Department of Transportation

US024G/MP 323.06 (E-X)
El Paso County

September 26, 2024

RE: Arrowhead Trailer Rural Home Occupation Expansion
AL2329

# PROPOSED SITE PLAN

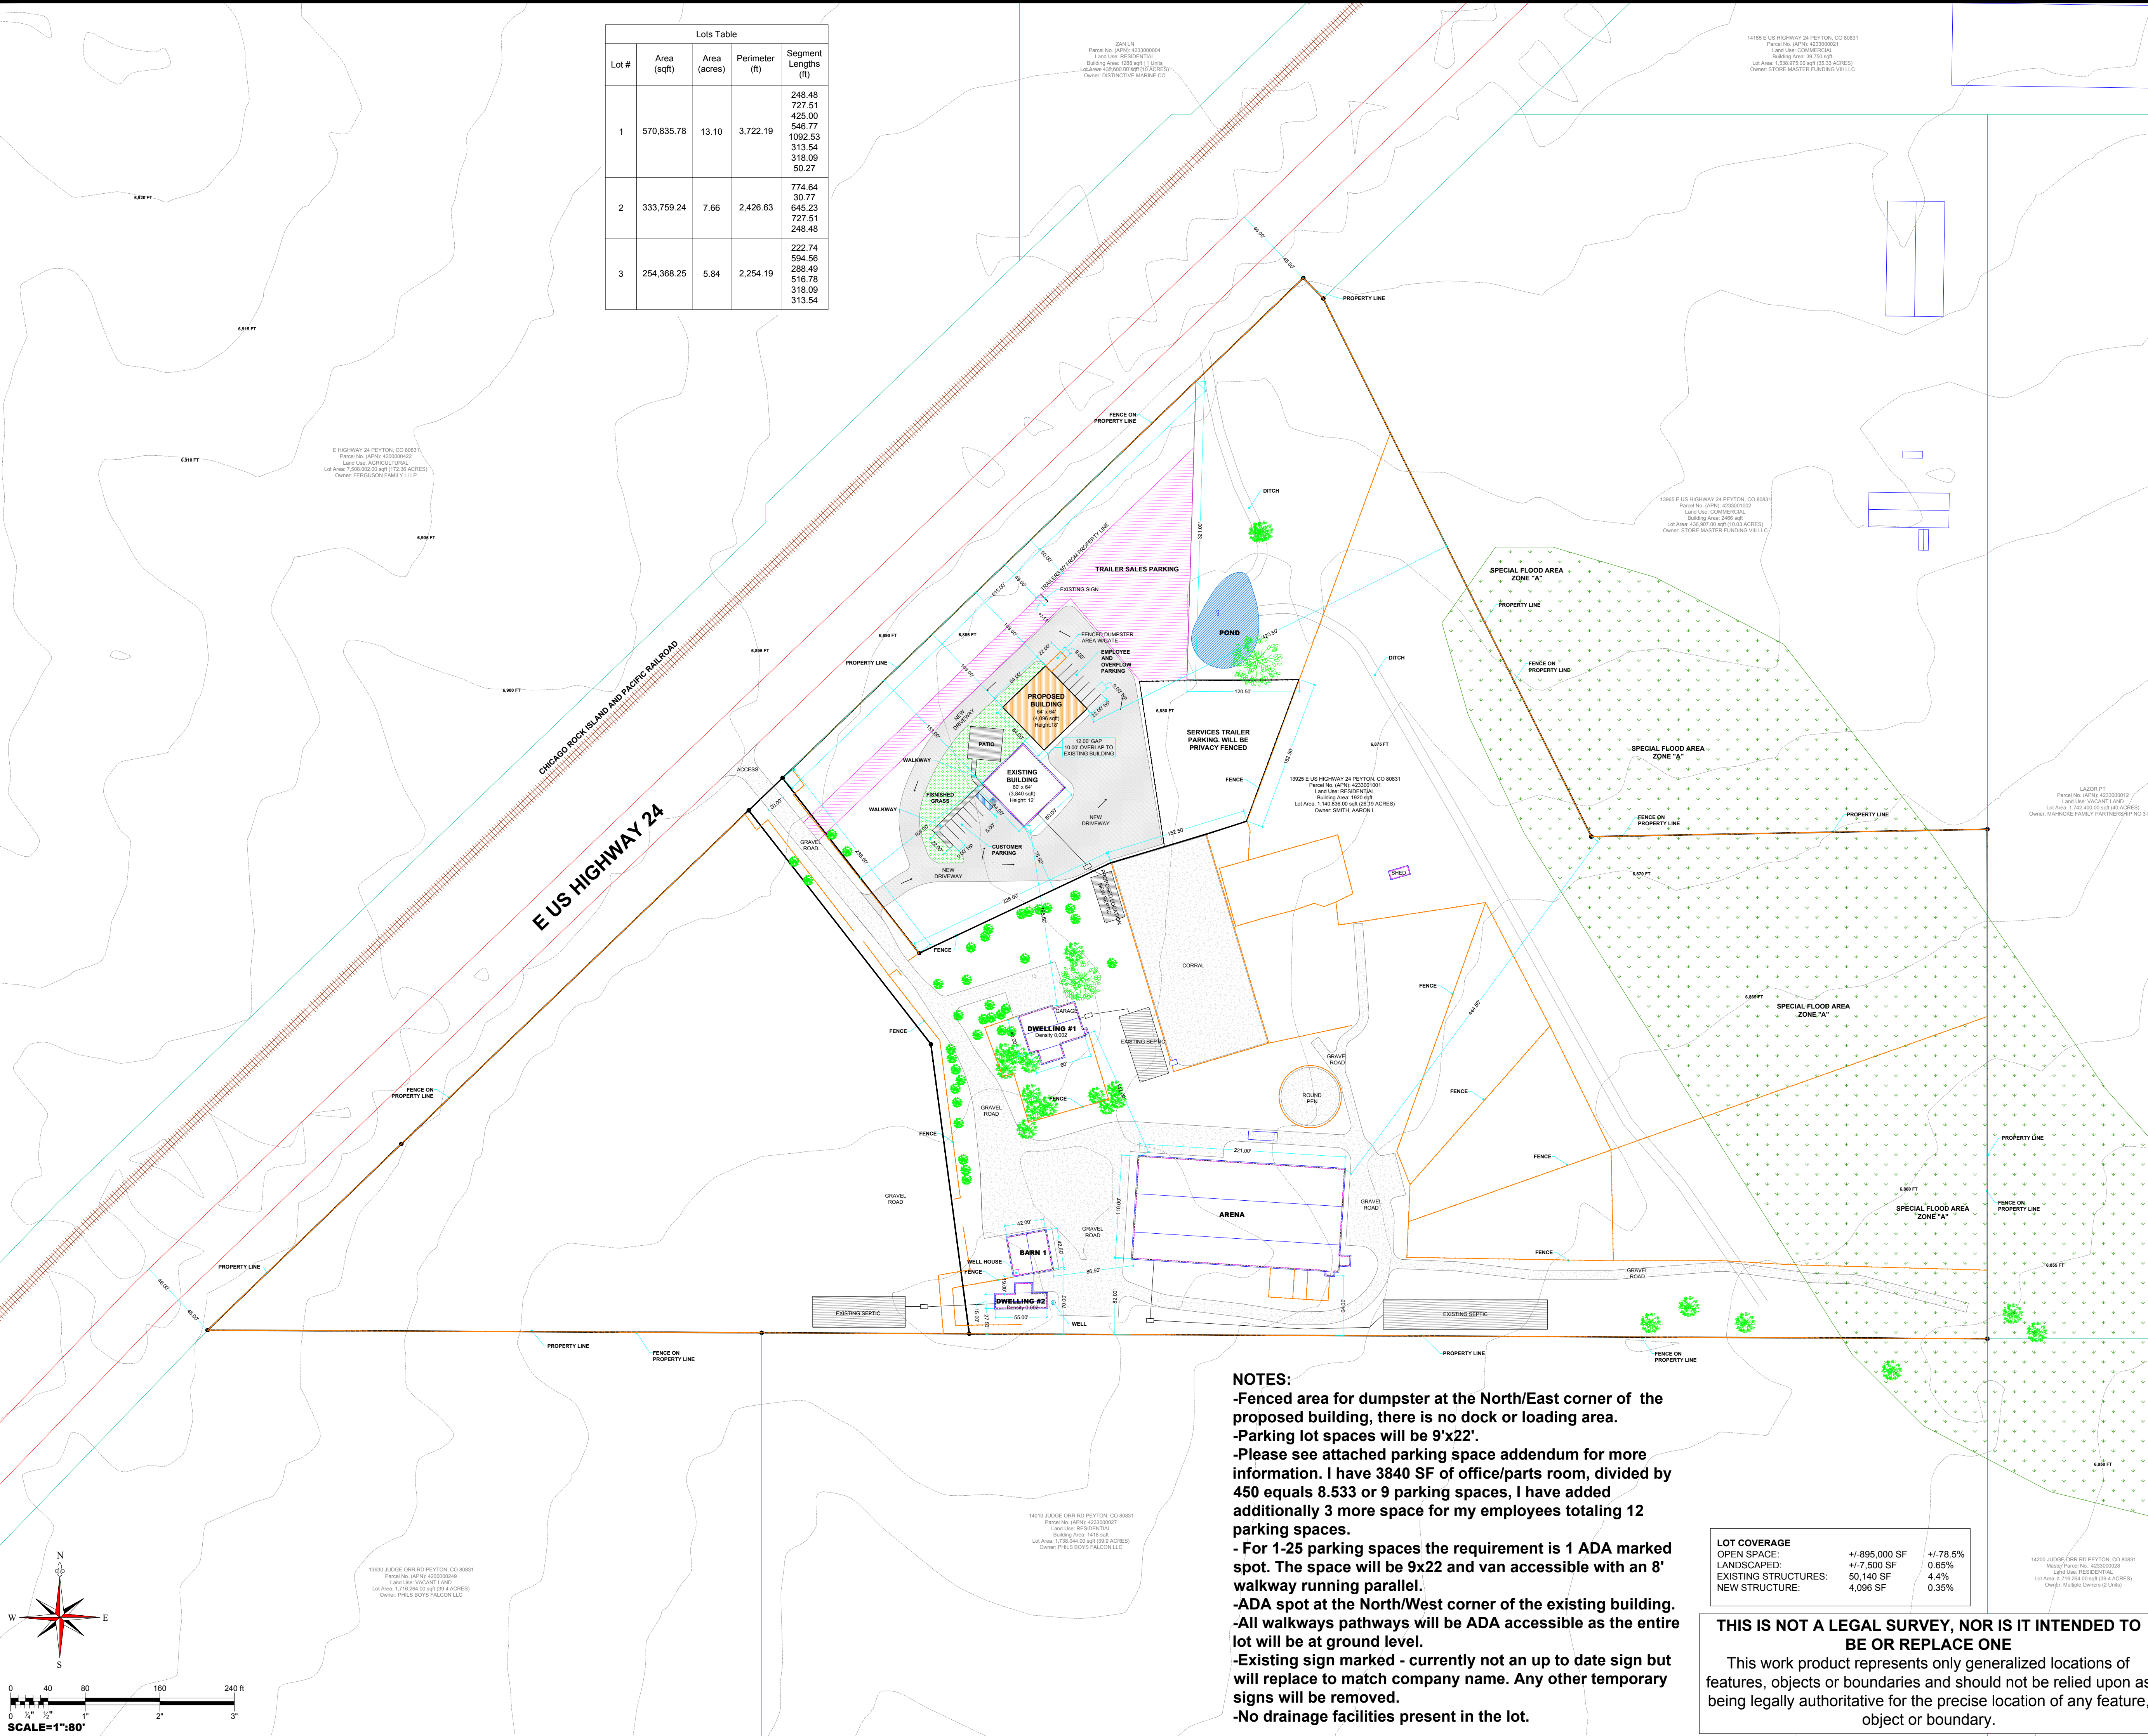
- An updated access permit will be required to document the change in use from the permitted use of a single-family residence to commercial. The existing access permit for this location (CDOT Access Permit #204114) is for a single-family residence with 12 horse stables.

- A Traffic Analysis, prepared by a Colorado registered professional engineer, is required to assess impacts at US Highway 024G.
 - The following traffic analysis elements for the intersection are required:

- Engineer's recommended improvements, if any.
- An Access Control Plan (ACP) for US 24 was approved by affidavit on June 1, 2006.
 - Per the ACP Term #57: Access 57 (Exhibit B, Figure 7/8, MP323.06): Existing private road with full movement access on the southeast side of US HWY 24. Access will be closed. Access will be shared using a frontage road routed to Judge Orr Road and Future Stapleton Road.
